**A/110/20/RES**

**Land South of Water Lane Angmering**

Approval of reserved matters following A/99/17/OUT for the Bridge over the Black Ditch providing access to the approved development. This application may affect the setting of listed buildings, may affect the character & appearance of the Angmering Conservation Area & falls within Strategic Site SD9, CIL Zone 1 (Zero Rated).

DRAWING 46353-STN-SBR-AB-DR-CB-0101

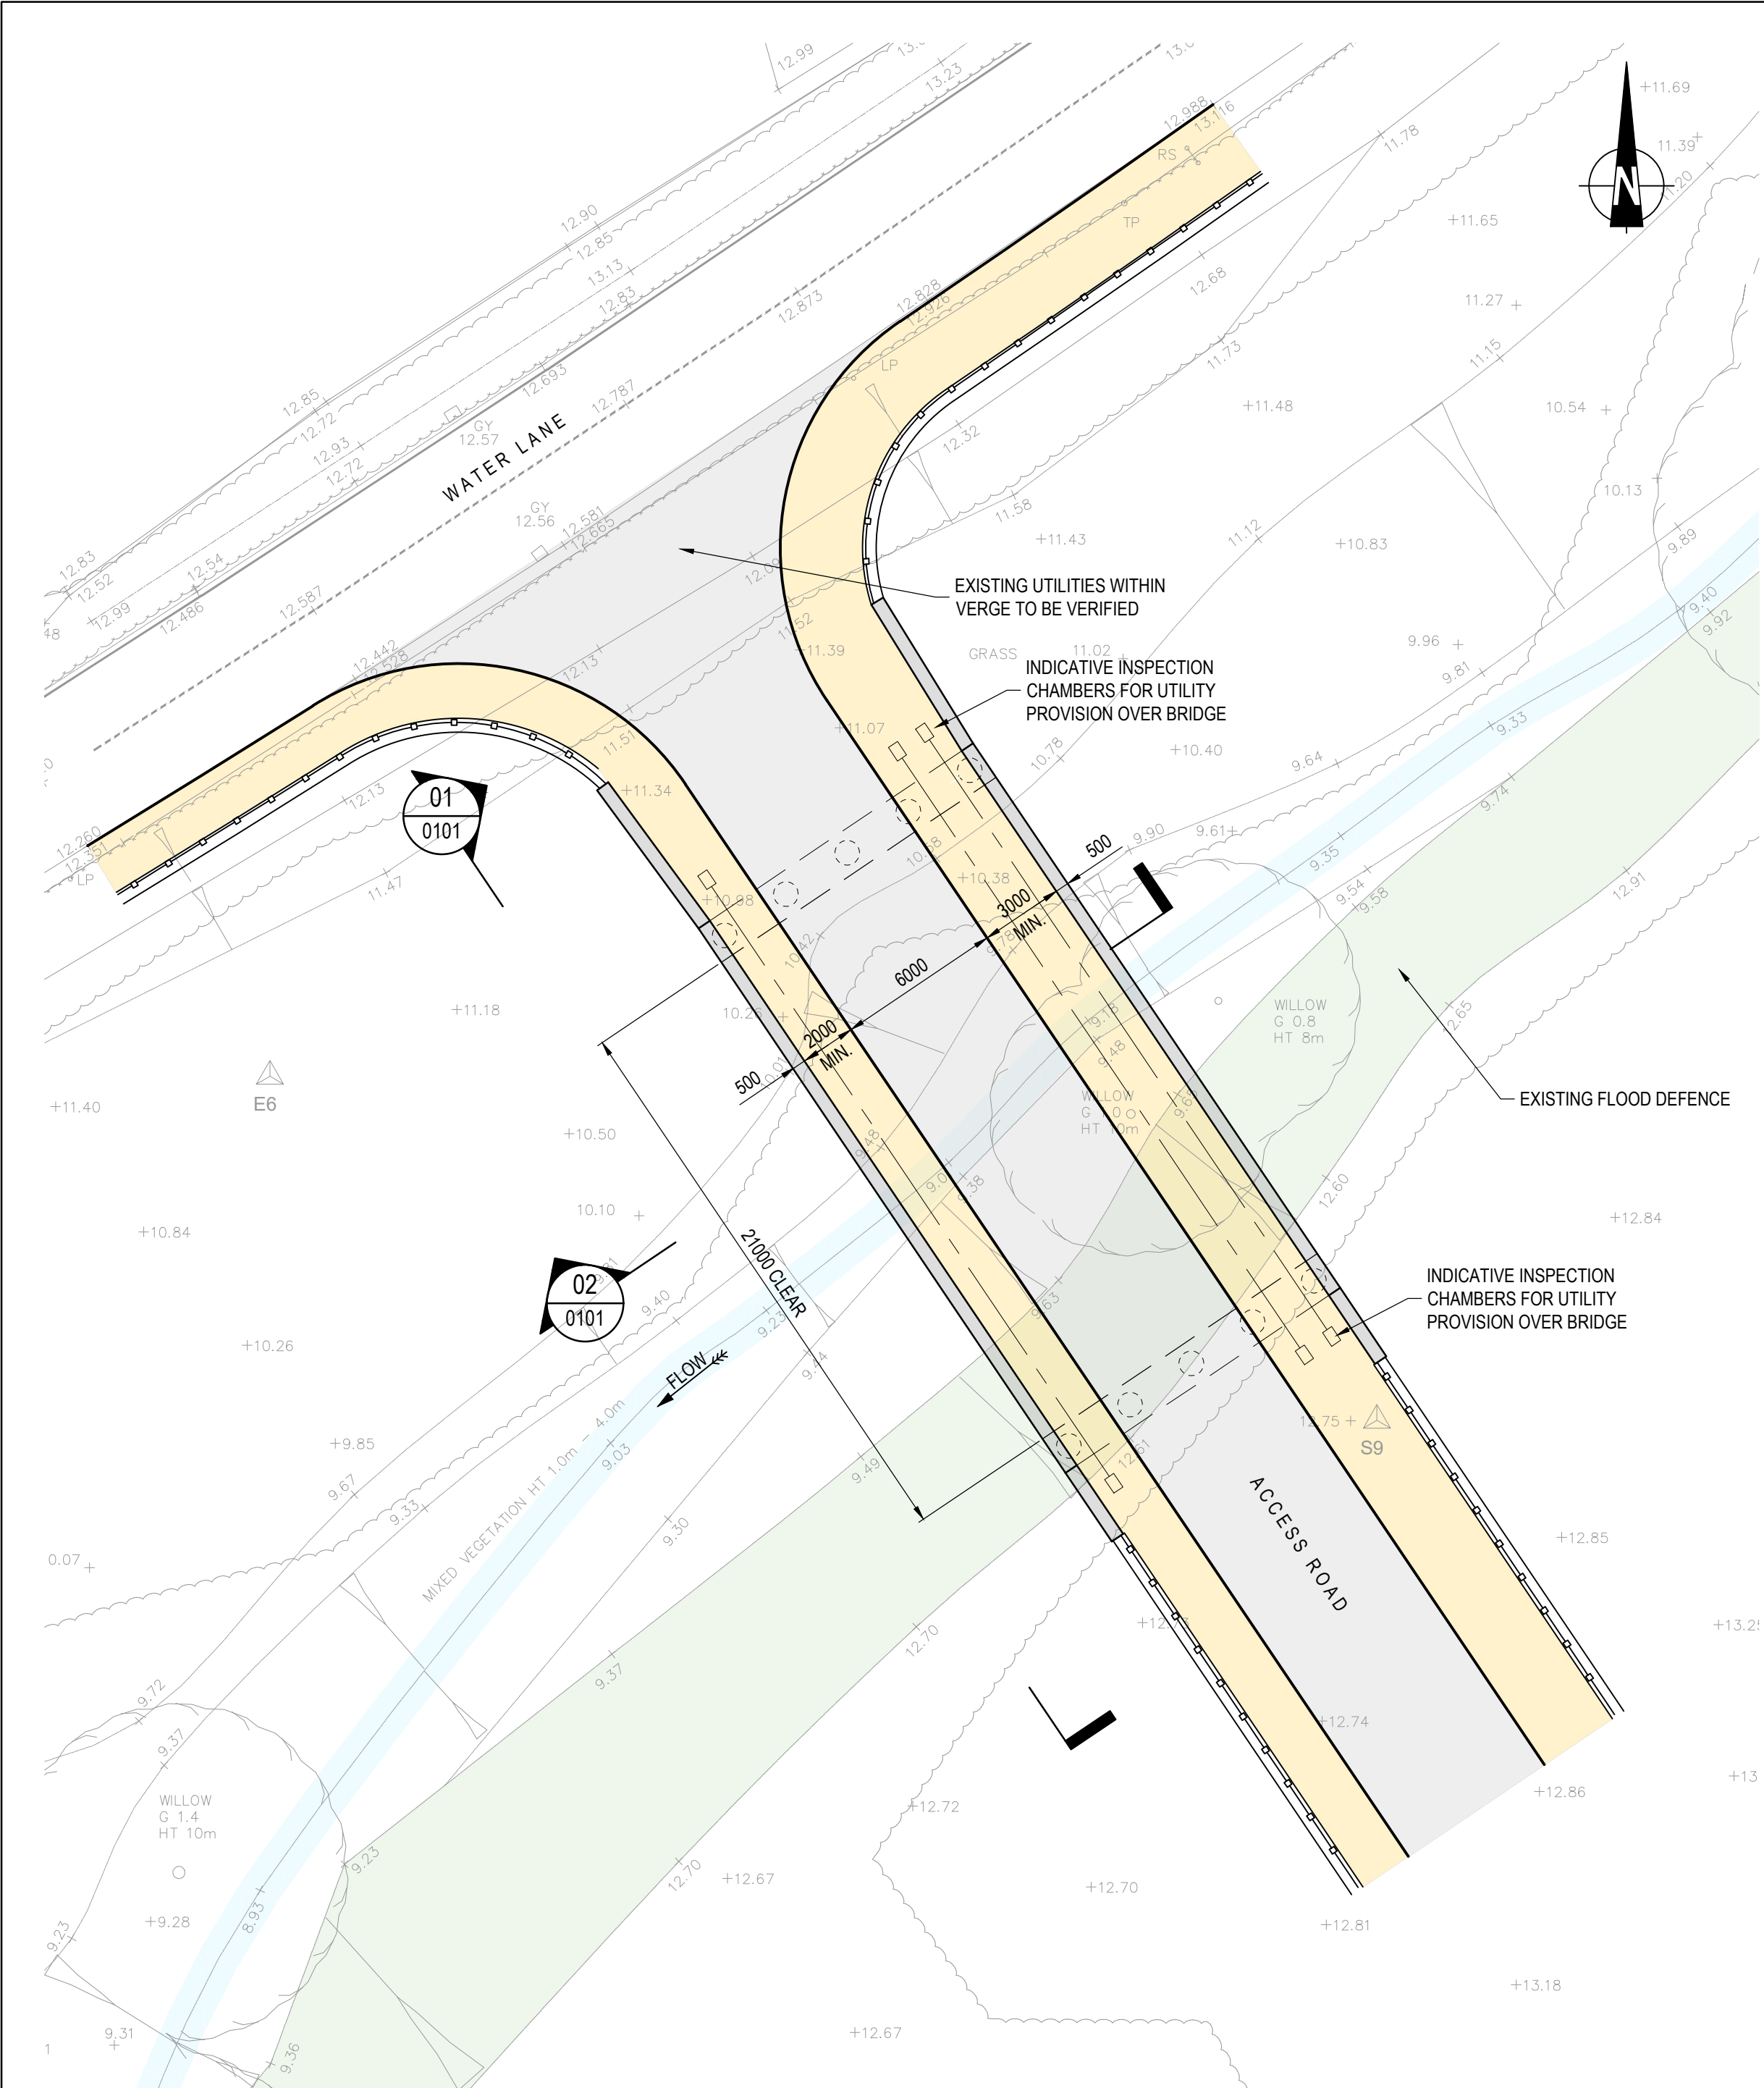
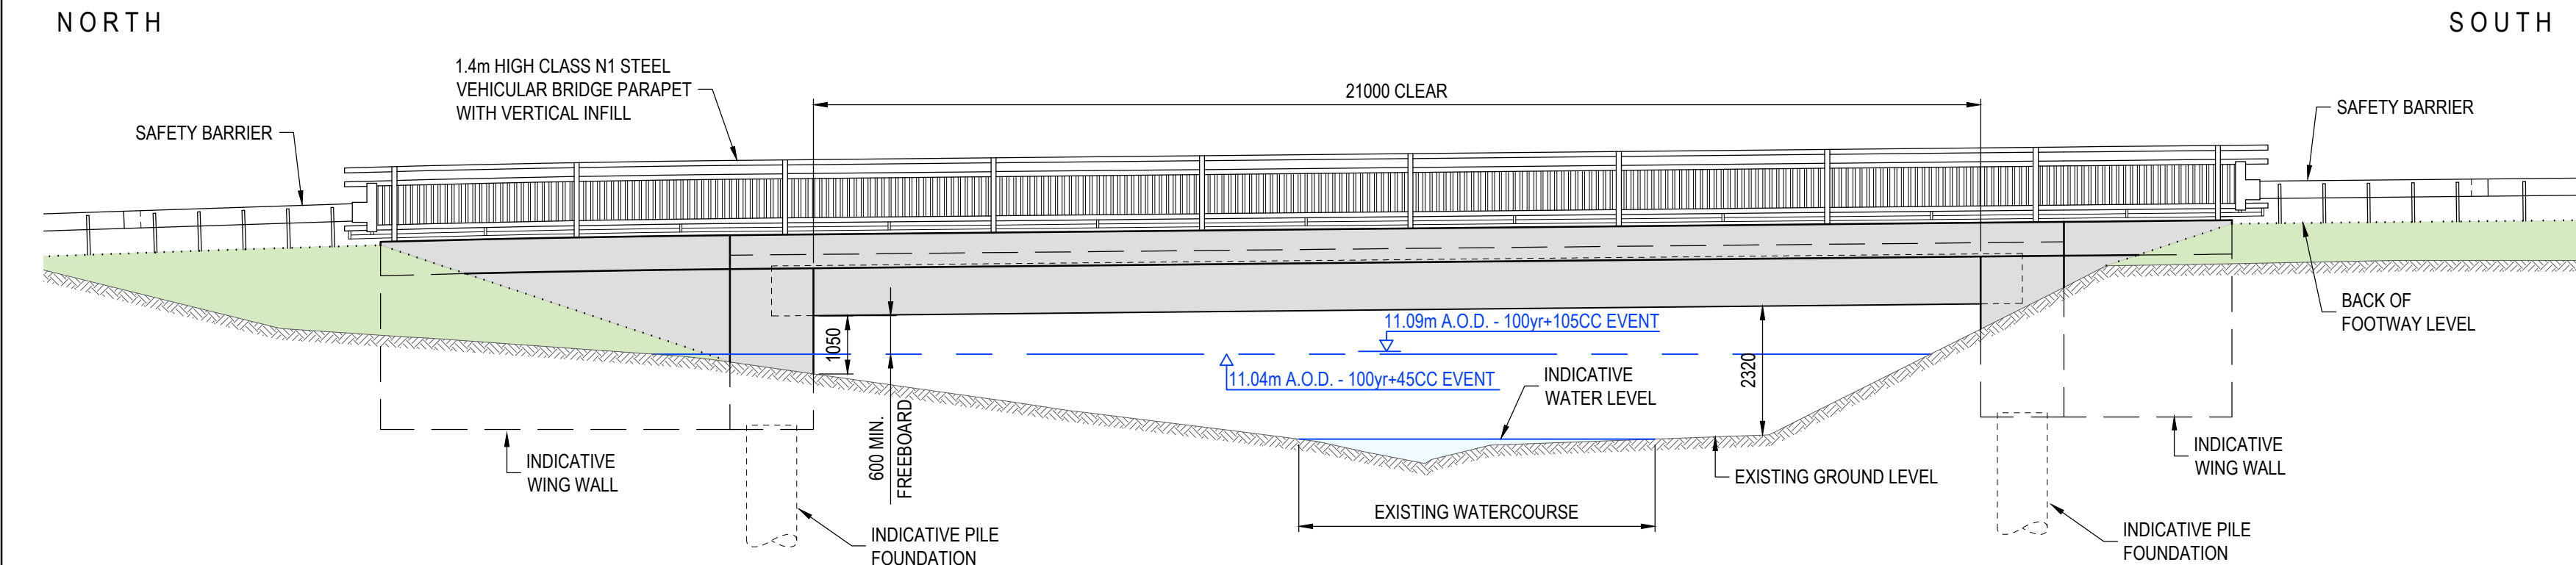
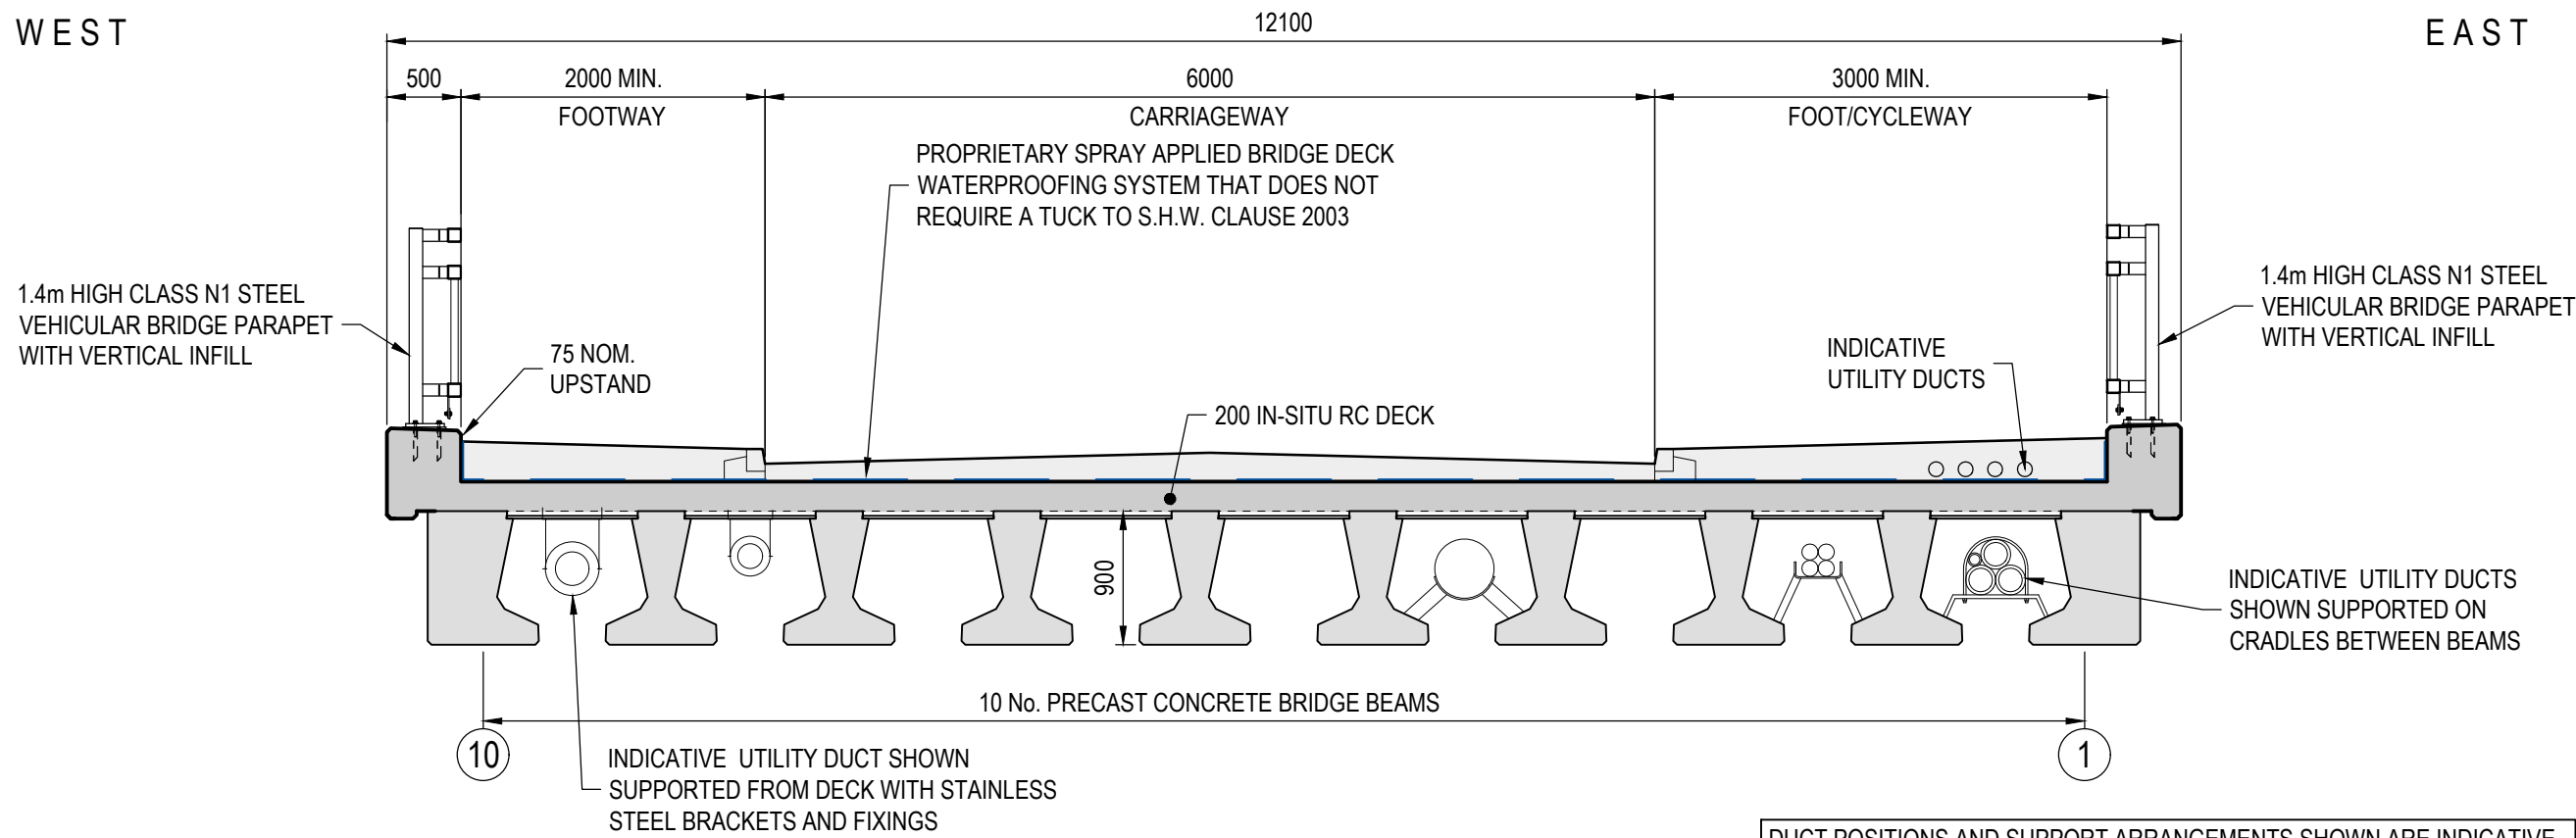
The second paragraph above is particularly pertinent. Firstly, it refers to the flooding problem downstream due to the inadequate conveyance capacity of the Black Ditch highway culvert. Secondly, it seems to me that if, instead of the clear span bridge proposed as part of Application A/110/20/RES, a highway embankment/dam carrying a road at the same level as the bridge deck is substituted, and the drainage calculations in A/109/20/RES are reworked to rely on attenuation online on the Black Ditch upstream of the highway embankment/dam, a more effective solution will be achieved delivering wider benefits and reducing flood risk overall.

The throttling control measure for Black Ditch flow through the dam would operate to ensure that critical water levels downstream are maintained below levels that would result in flooding. Such a system of operation is relatively easy to achieve.

This would greatly simplify the drainage attenuation requires elsewhere on the Application site since the real benefit will be achieved strategically.
